DECISION DELEGATED TO DEVELOPMENT MANAGER

Application No: H23-1158-20 **Applicant:** Mr D Carroll
Proposal: Demolition of dwelling and erection of 3 houses
Location: Springway Stockwell Gate Whaplode
Terminal Date: 22nd February 2021

Proposed F.F Layout

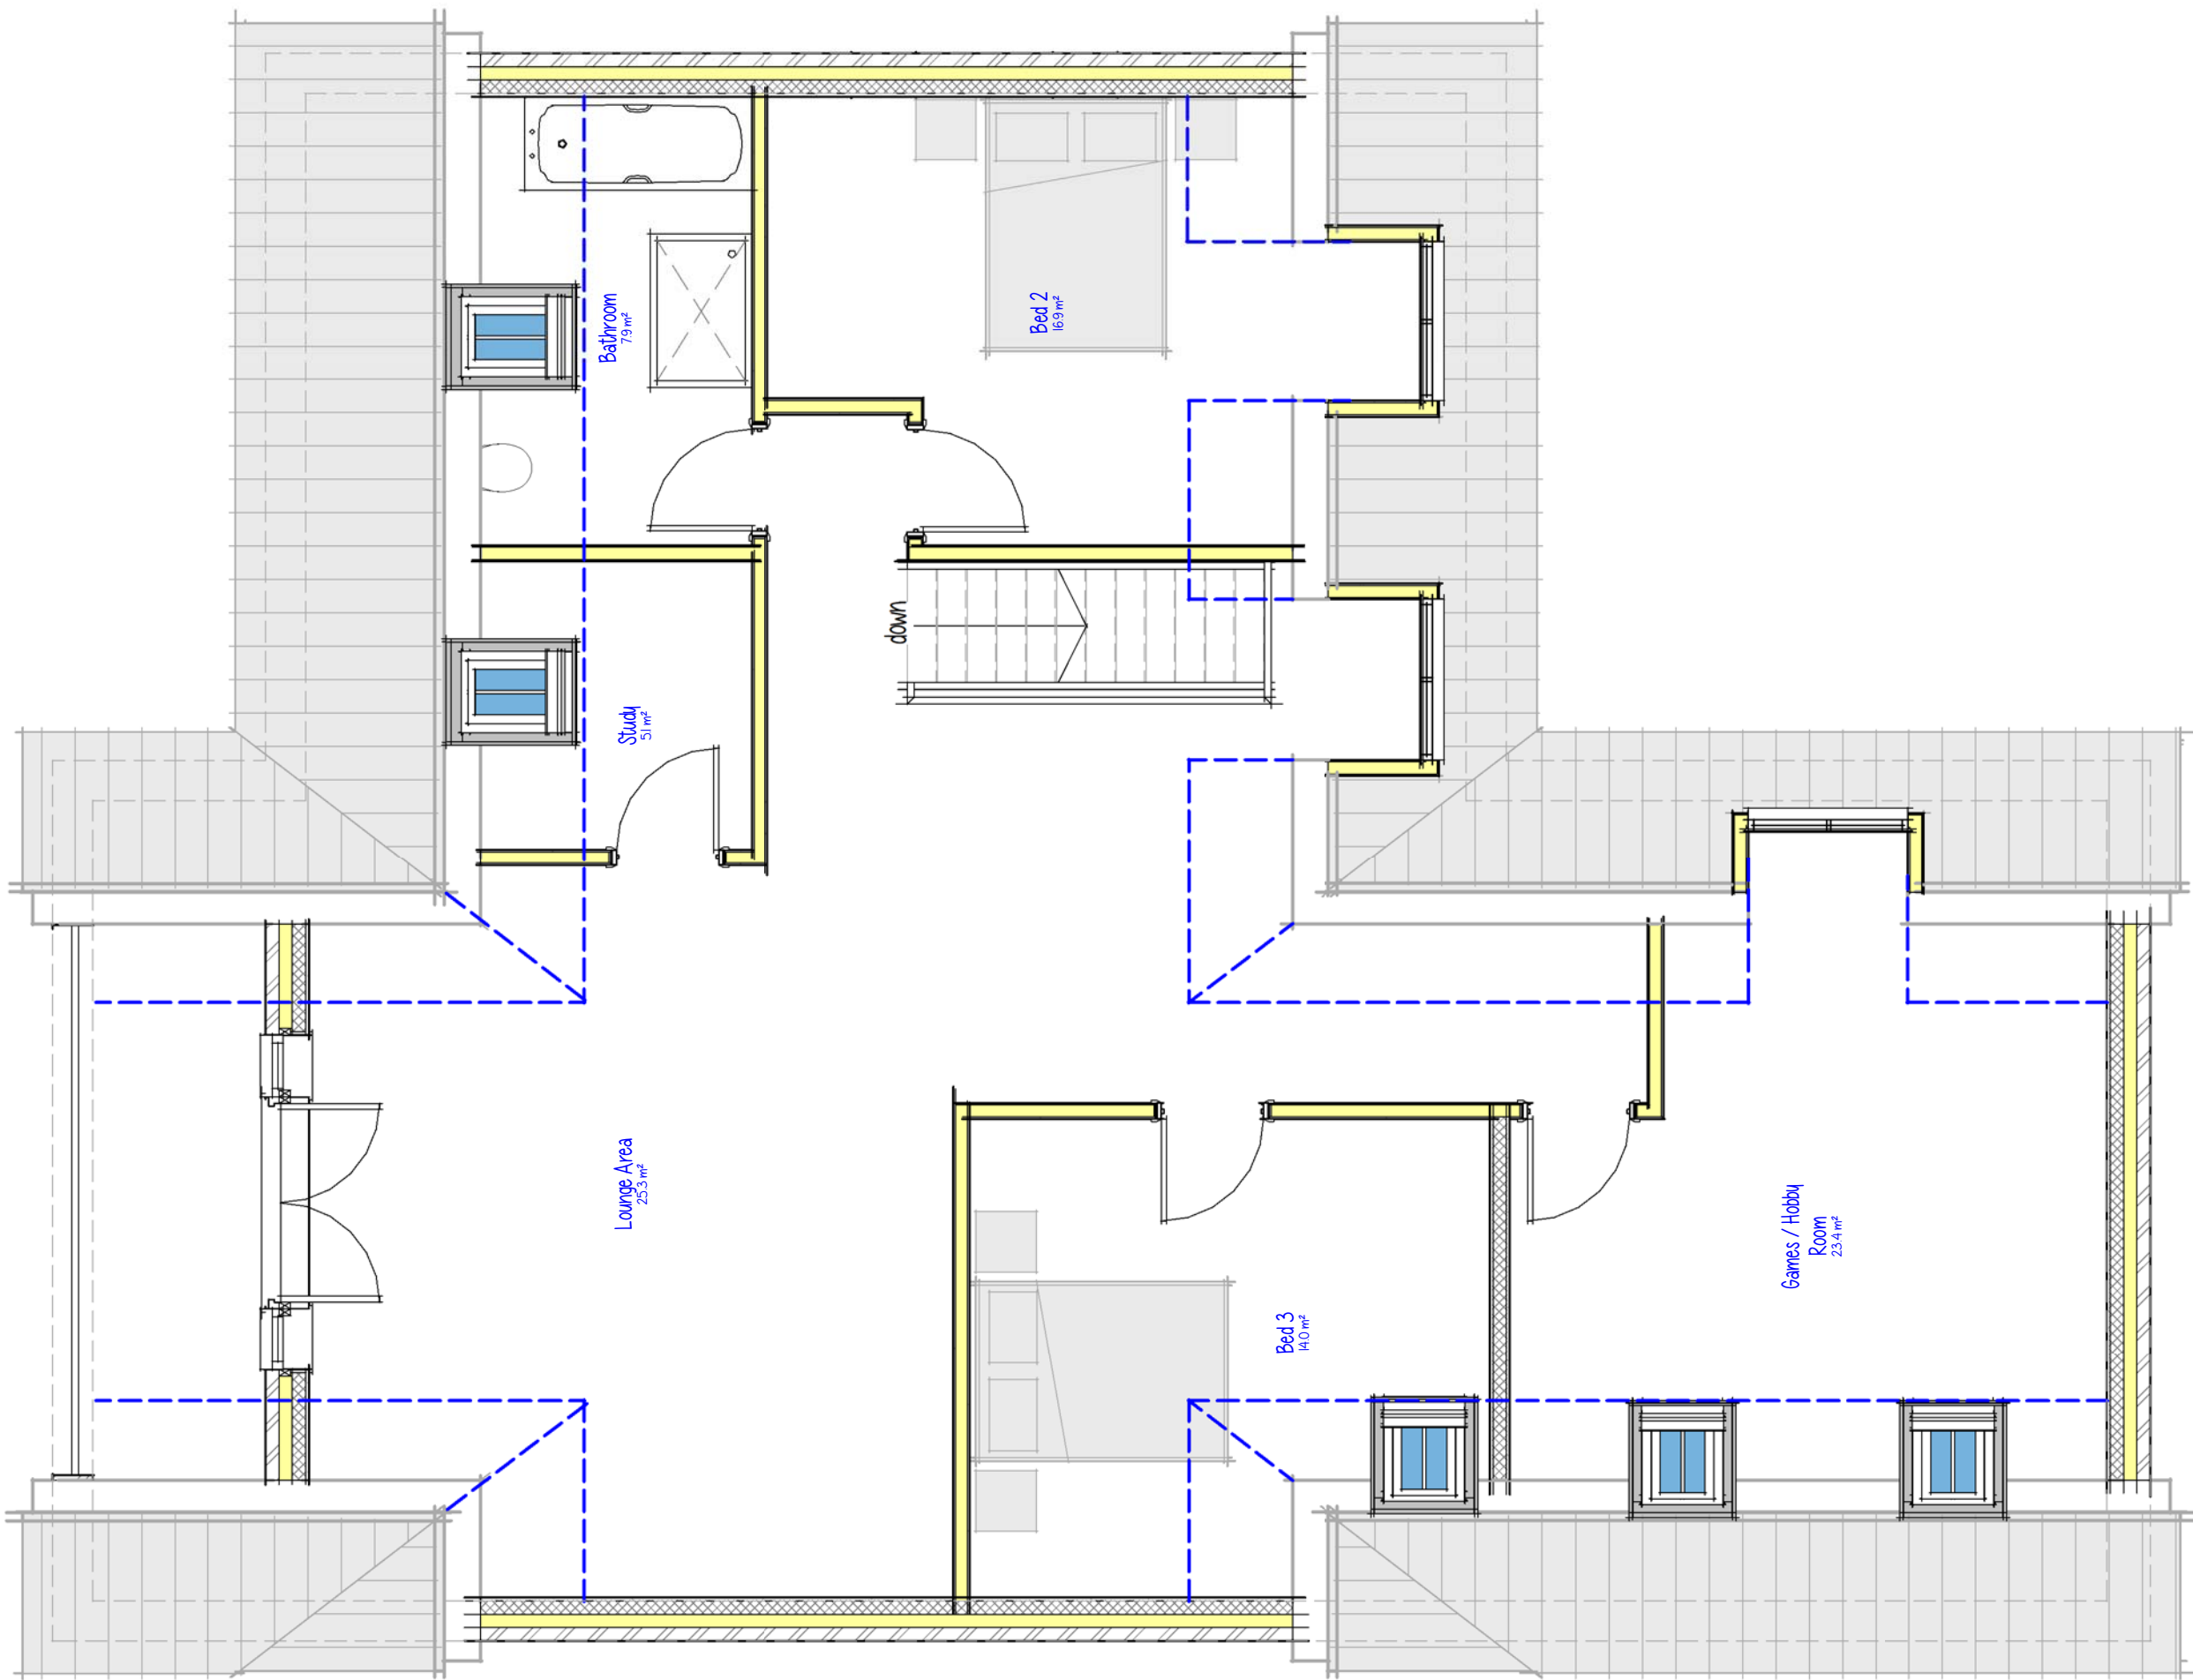
However, it is concerning the relationship between Plot 3 and Plot 1. The separation distance would be 19.20 metres between the dormer window of Plot 3 facing eastwards and the first-floor rear bedrooms windows in Plot 1. The distance would be shorter between the dormer window and the rear garden. At such proximity, there might be significant overlooking effect that would undermine the amenity of future occupiers of Plot 1.
